WEST SUSSEX COUNTY COUNCIL CONSULTATION

TO:	Arun District Council FAO: Simon Davis
FROM:	WSCC - Highways Authority
DATE:	1 September 2020
LOCATION:	The Former Ship Inn Aldwick Street Aldwick PO21 3AP
SUBJECT:	AW/197/20/PL Variation of conditions 8-concerning hours of deliveries & 10 types of vehicles making deliveries following AW/211/14/PL. This application is in CIL Zone 4 (Zero Rated) as 'other development'.
DATE OF SITE VISIT:	n/a
RECOMMENDATION:	No Objection
S106 CONTRIBUTION TOTAL:	n/a / £ See below for breakdown.

Client
Surplus Property Investments
 Project
The Former Ship Inn, Aldwick Street, Bognor Regis. PO21 3AP
 Title
Highway details with Vehicle Tracking : Articulated Delivery Vehicles

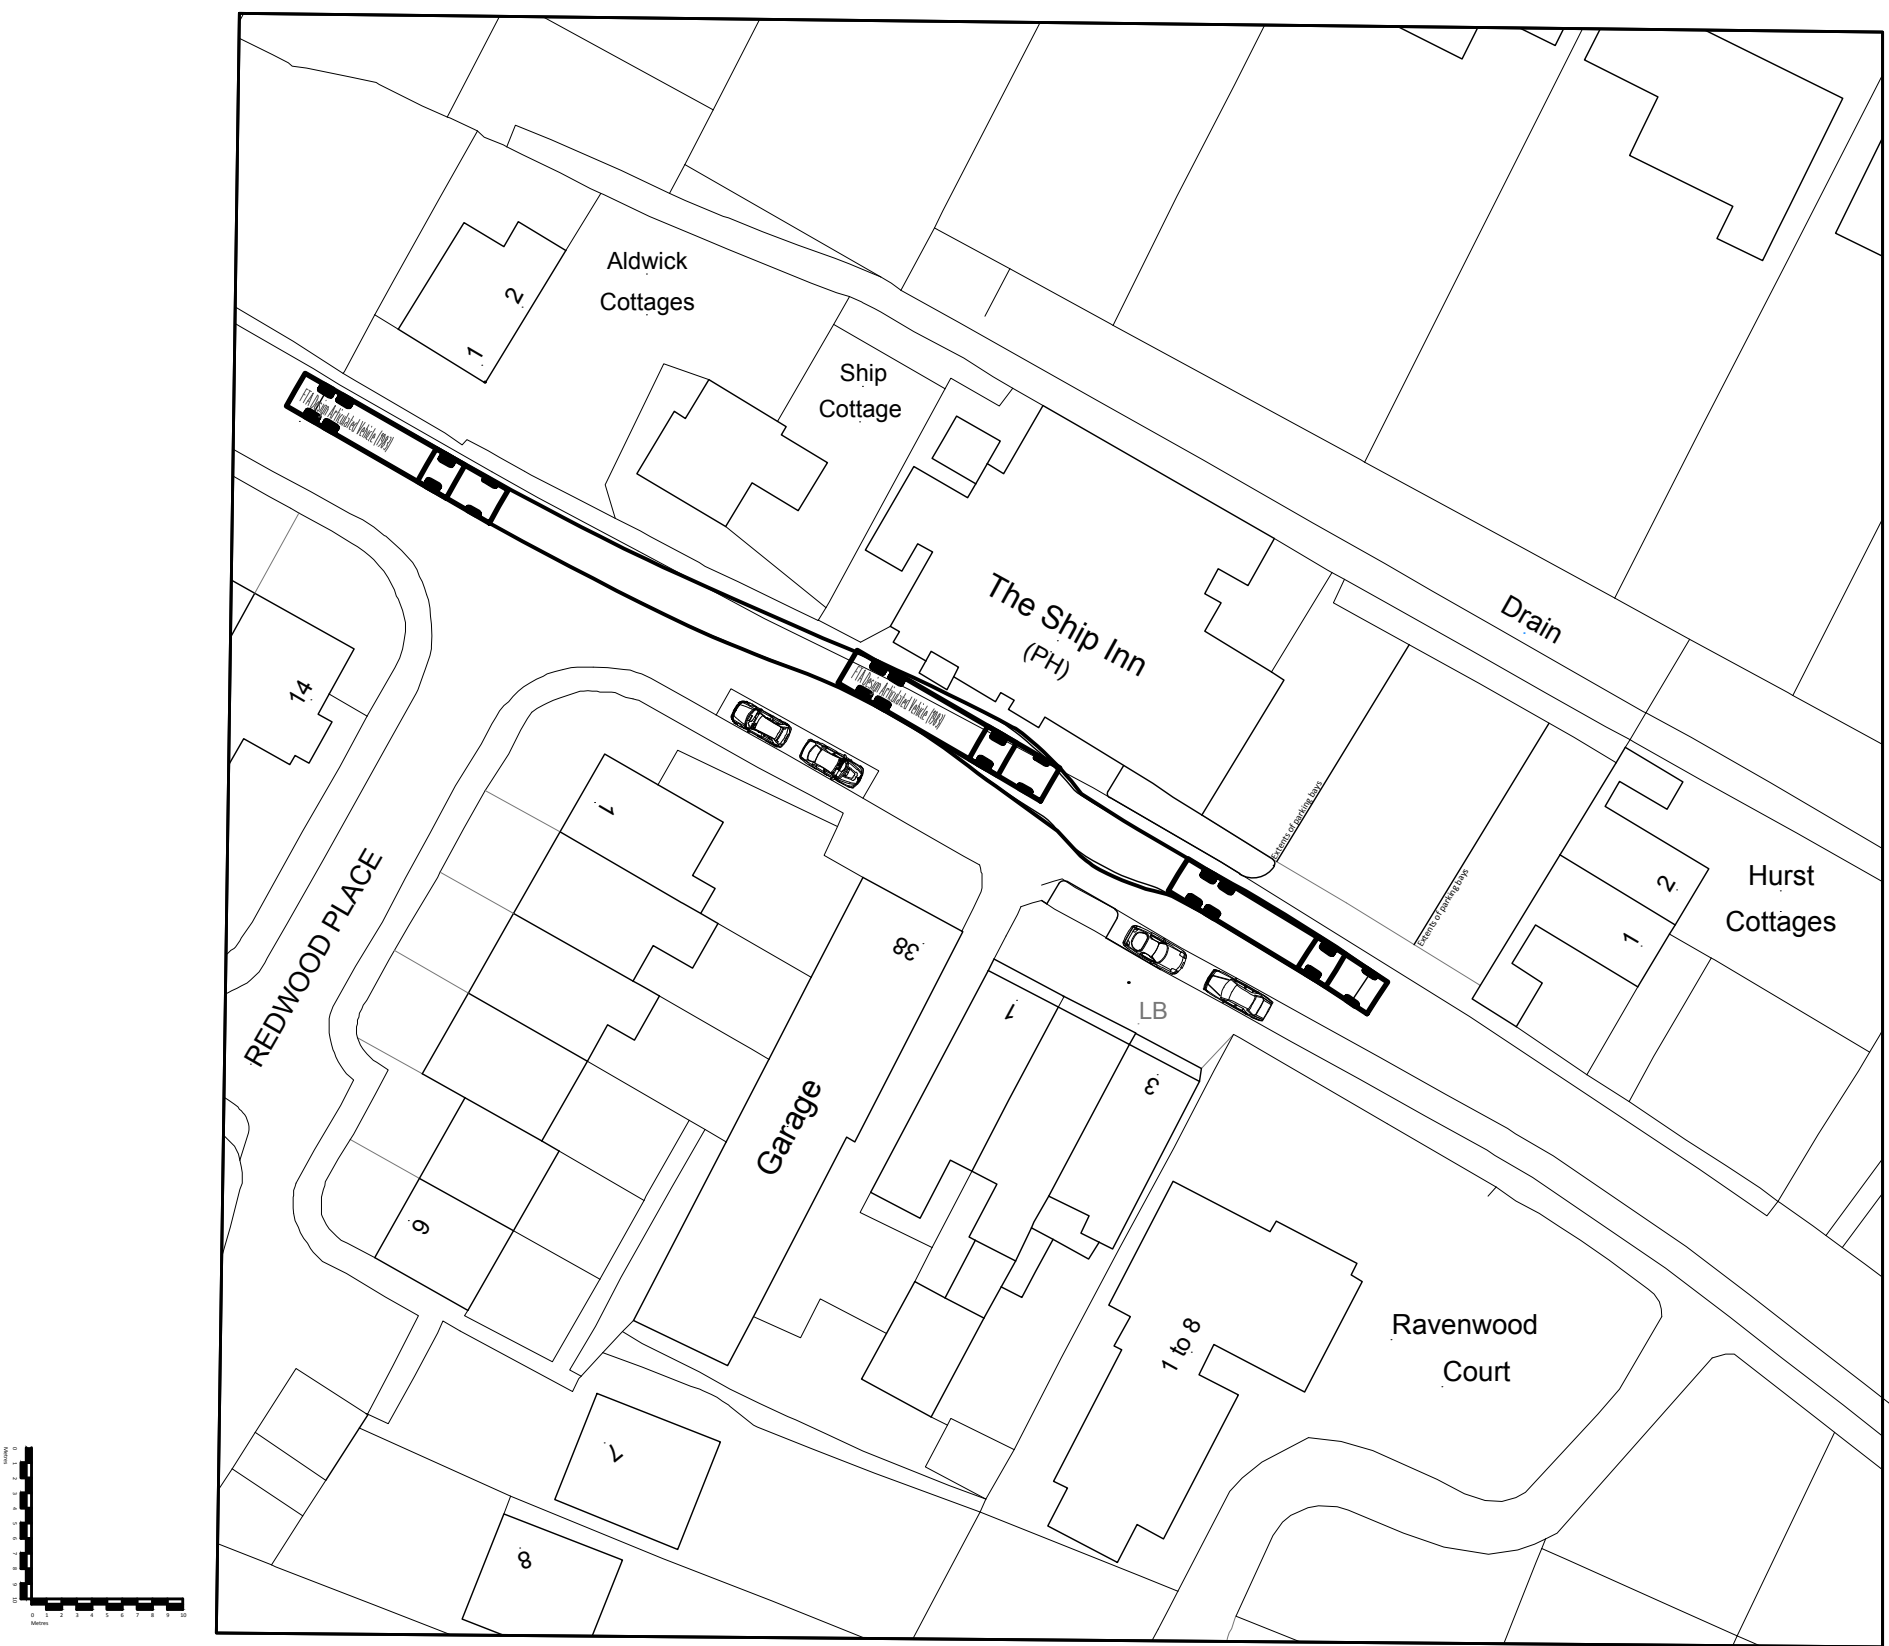
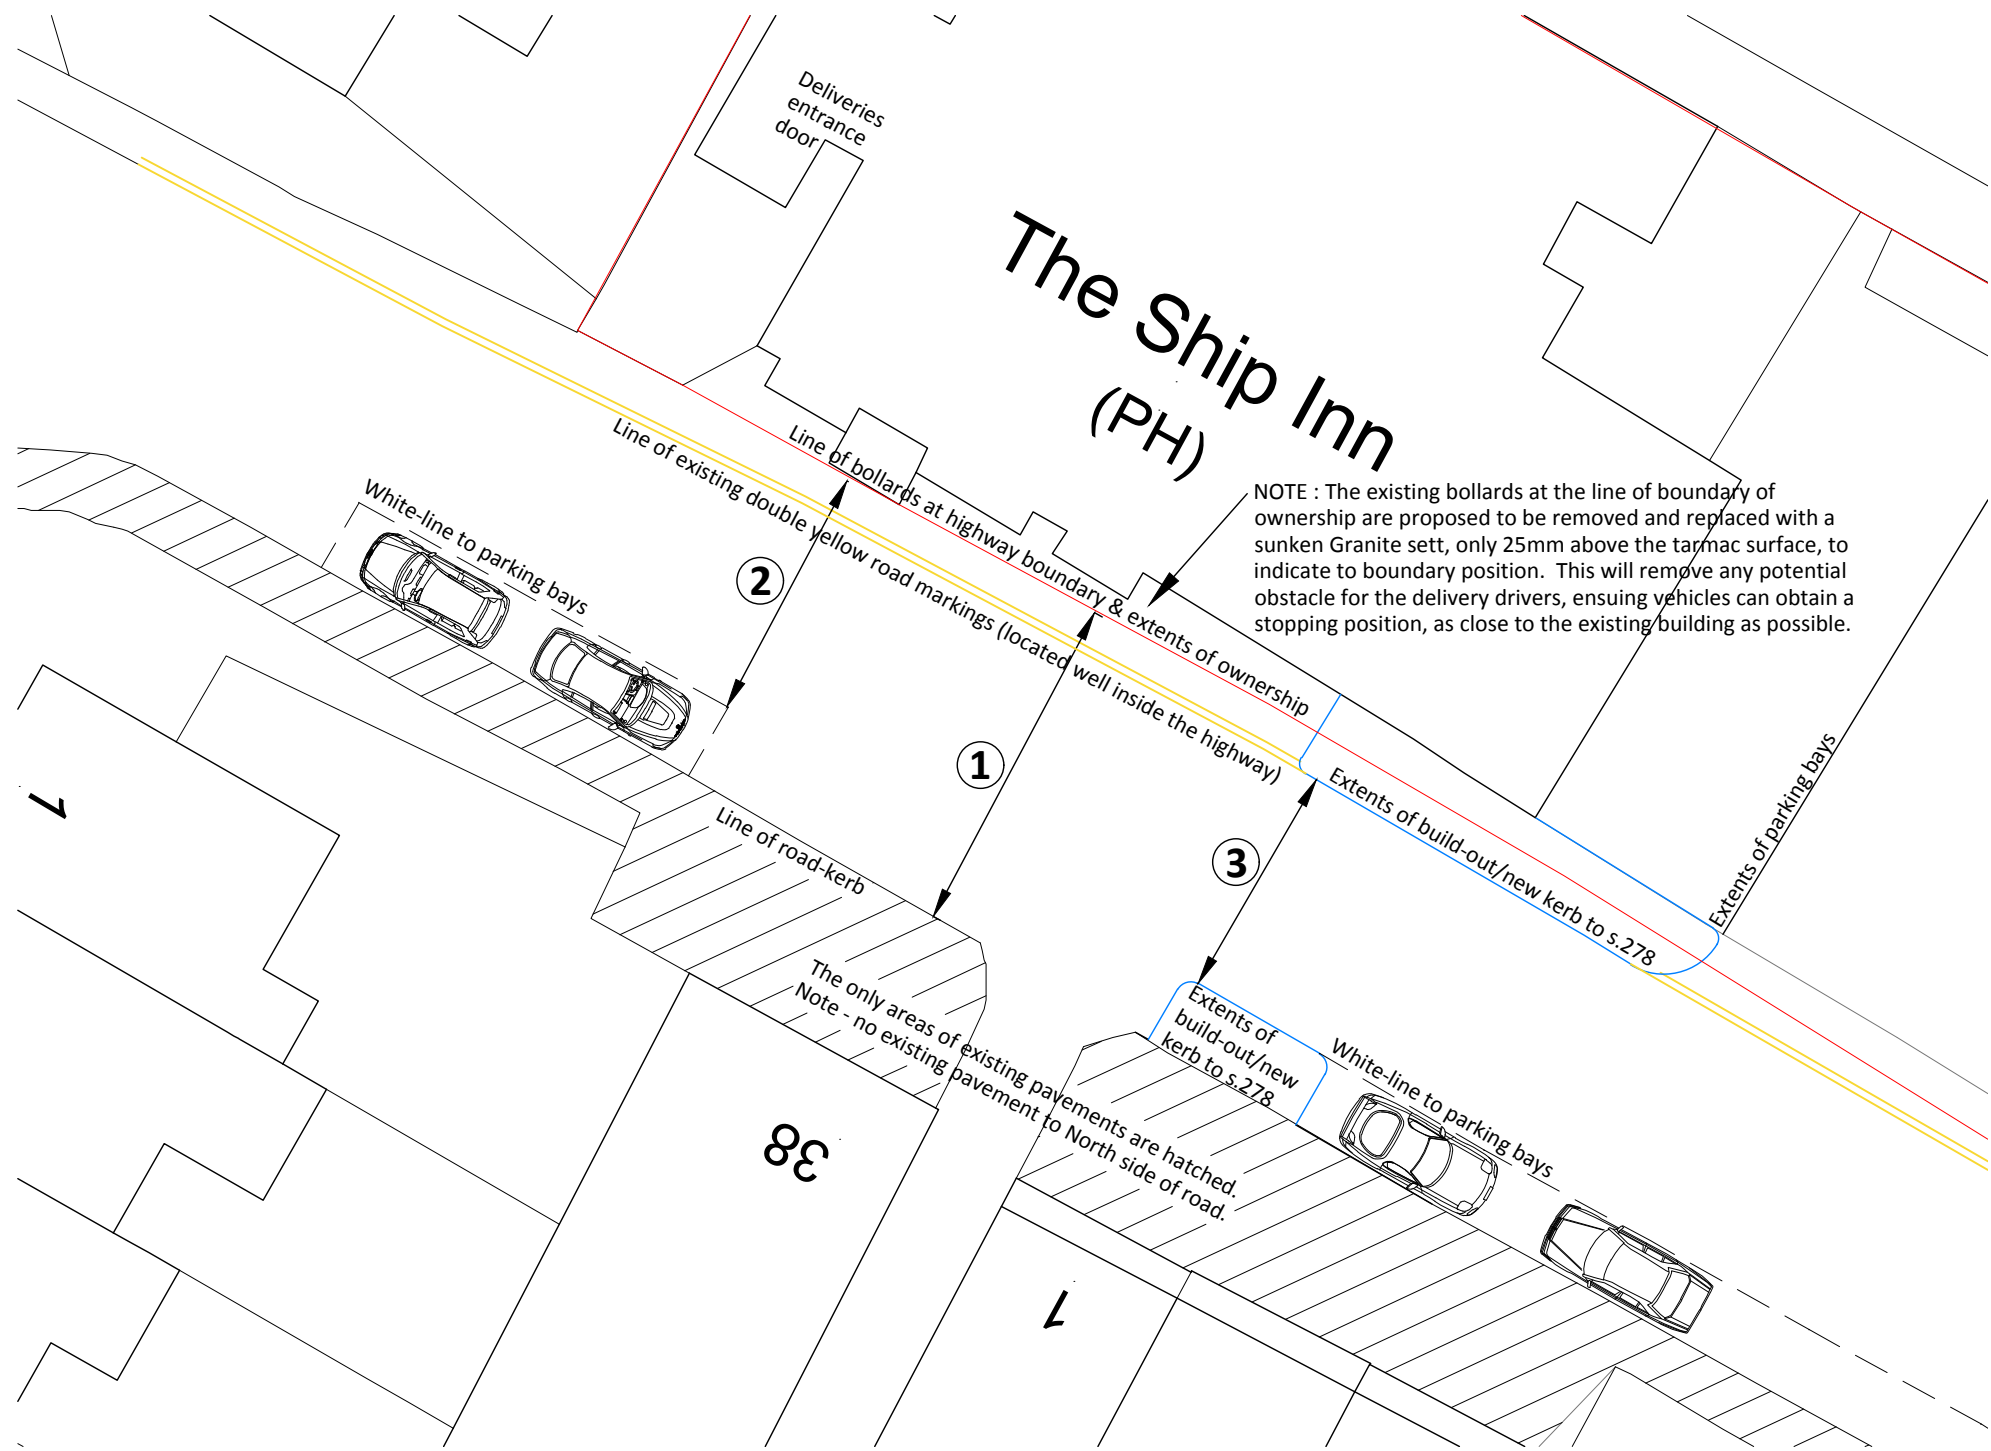
It is noted the largest vehicle used in the delivery management plan would be an articulated vehicle with dimensions of 2.6m in width and up to 16m in length. It has been said this will only be used on rare occasions and given the street dimensions would still allow a car or refuse truck to pass freely. Based on the submitted highway plan which shows the dimension of the road at three points, it is

confirmed that a 2.6m wide articulated lorry parked on the highway would still leave 3.6m available for one vehicle to pass safely.
